Re: Wallarah 2 Coal Project – Amended Development Application (SSD 4974)

Thank you for the opportunity to review the environmental impact assessment for the amended project. The Central Coast Public Health Unit (PHU) has consulted with the NSW Ministry of Health, Environmental Health Branch, in preparing this response.

The following comments relate to 'Walarah 2 Coal Project Air Quality and Greenhouse Gas Assessment – Addendum' (AQGGA-A), published 4 July 2016. The comments provided in this letter are contingent upon the Environment Protection Authority's (EPA) confirmation that the modelling approach is appropriate. If this was found not to be the case, our findings would need to be reconsidered.

Day Time Noise Contours (Worst Case)

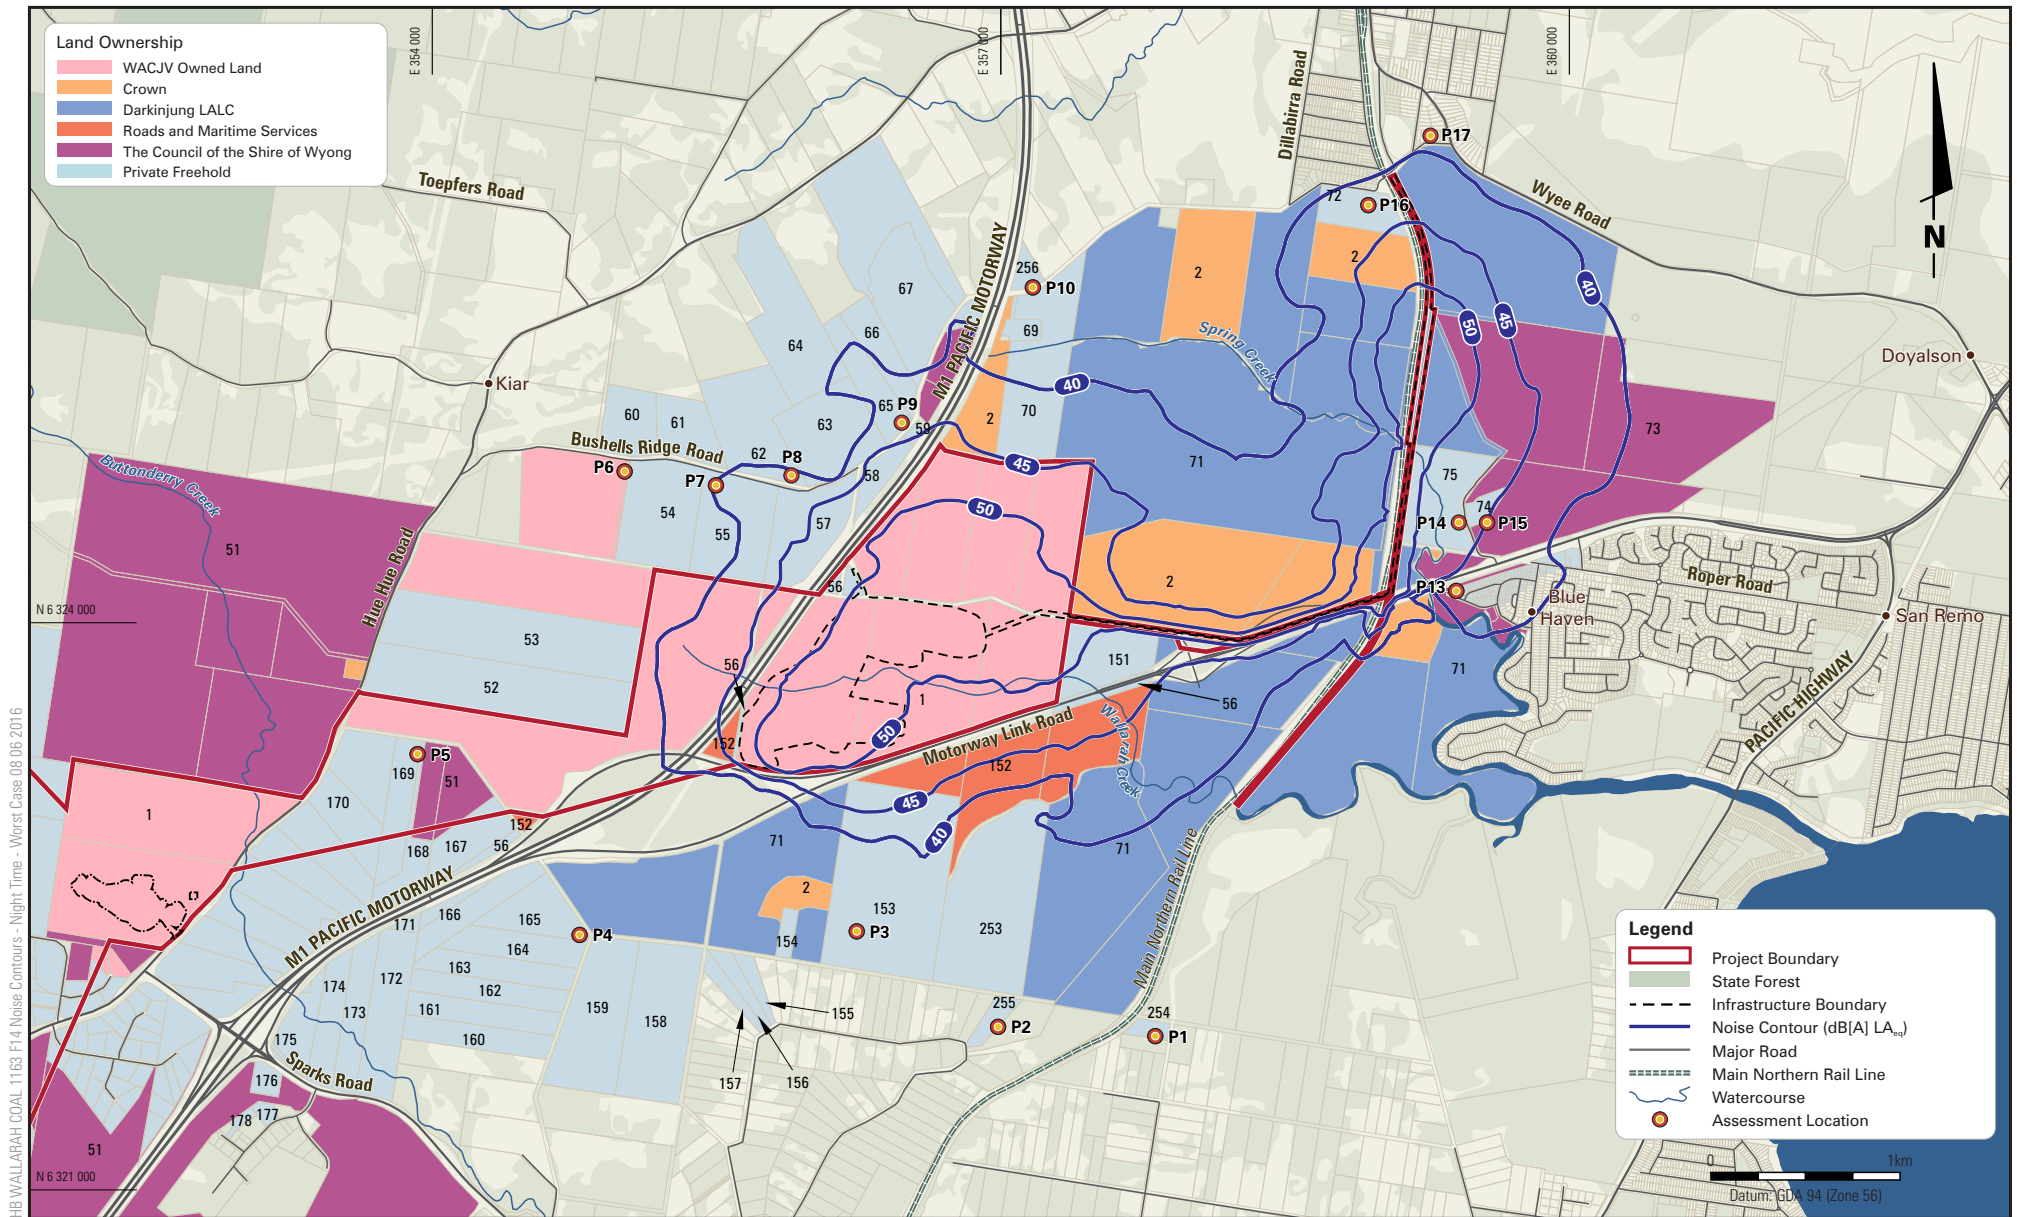
The Amended DA notes that some properties (P14, P15 and P16) will experience increased noise levels and a moderate degree of affectation (Noise and Vibration Impact Assessment Addendum pp19 and 29). It is important that mitigation measures, at source or house, be implemented to ensure noise impacts are limited. Any remedial acoustic works to properties in the noise management zone should be to the satisfaction of the affected land occupier and the EPA.

In summary, the project's noise emissions have potential to affect a number of community members and so we believe the increased noise levels are not insignificant. We believe that more effective noise mitigation measures be implemented to avoid the described noise impacts to the Wyee and Blue Haven areas. These measures should be applied at the project, rather than to private properties. We defer to the EPA, but suggest that should the project proceed, as a minimum, the measures recommended in sections 7 and 11 of the Noise and Vibration Impact Assessment Addendum should be adopted and supported with appropriate approval and licensing conditions imposed.

Figure 8.12: Predicted Number of Days Over 24-Hour PM<sub>10</sub> Concentration at worst impacted residences

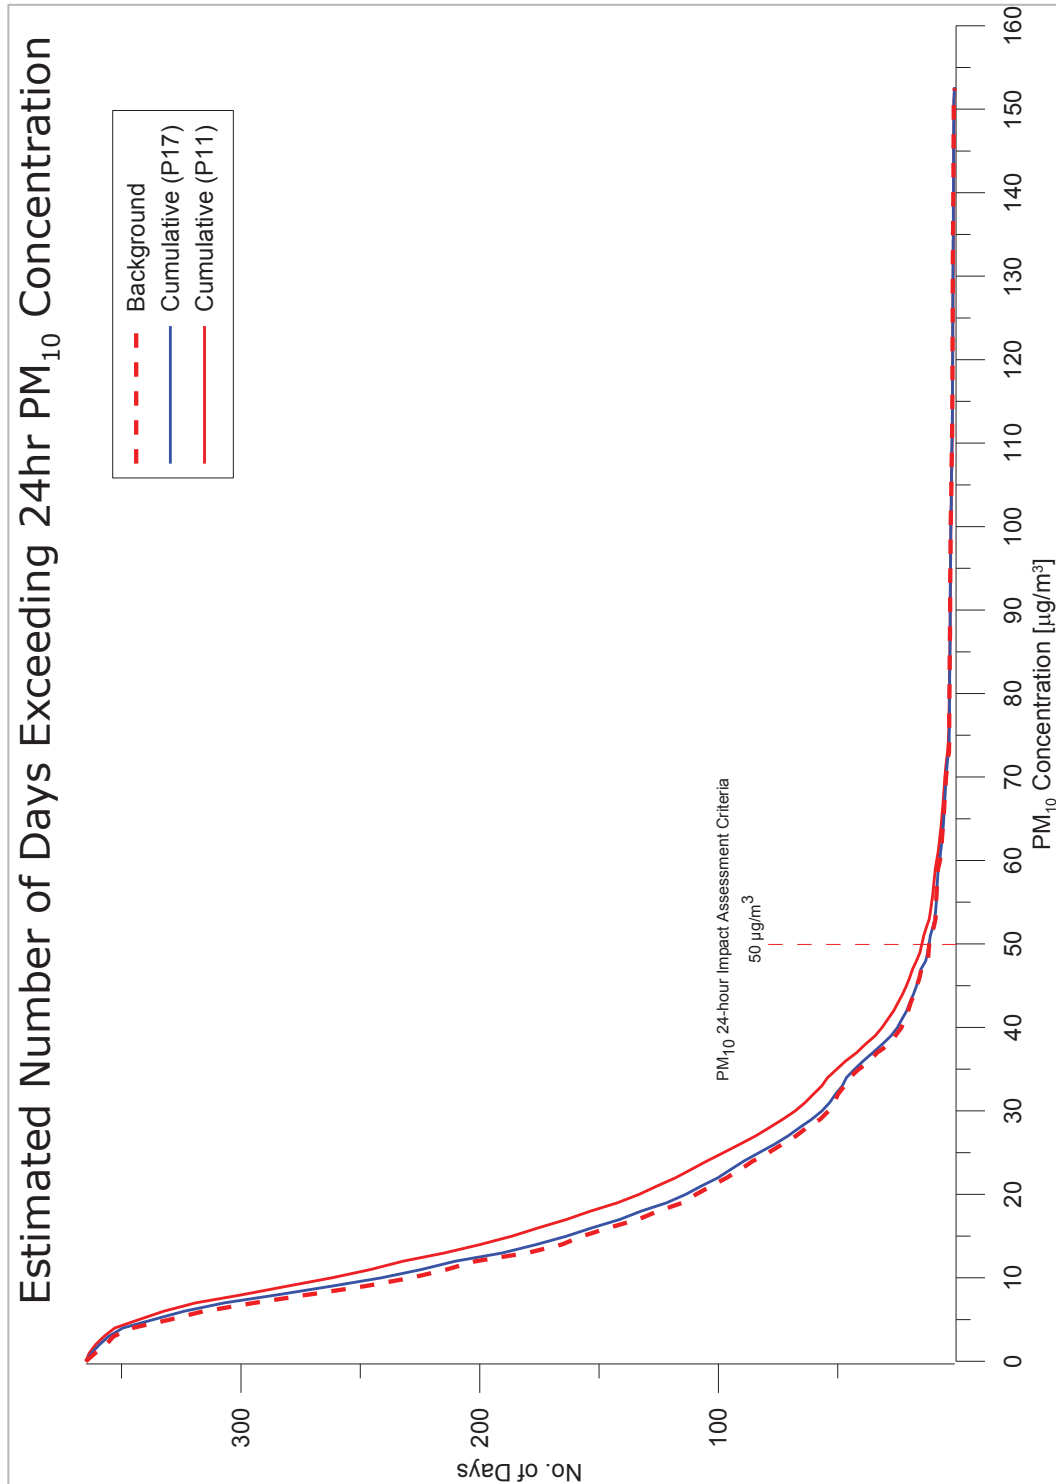
This proposal will increase the frequency of higher air pollution days - figure 7.7, p41, shows the estimated number of days exceeding background 24hr PM₁₀ concentrations for two sites. The graph shows that these premises are expected to see 15 to 20 additional days with a PM₁₀ above the more moderate level of 20ug/m³. For susceptible individuals, there is a risk of more frequent health events. While serious events are less common, less severe health outcomes are more likely (as outlined in Appendix M of the original EIS – ‘pyramid of health impacts’ and our previous submission of 26 June 2013). The risks for individuals will be influenced by any underlying health conditions.
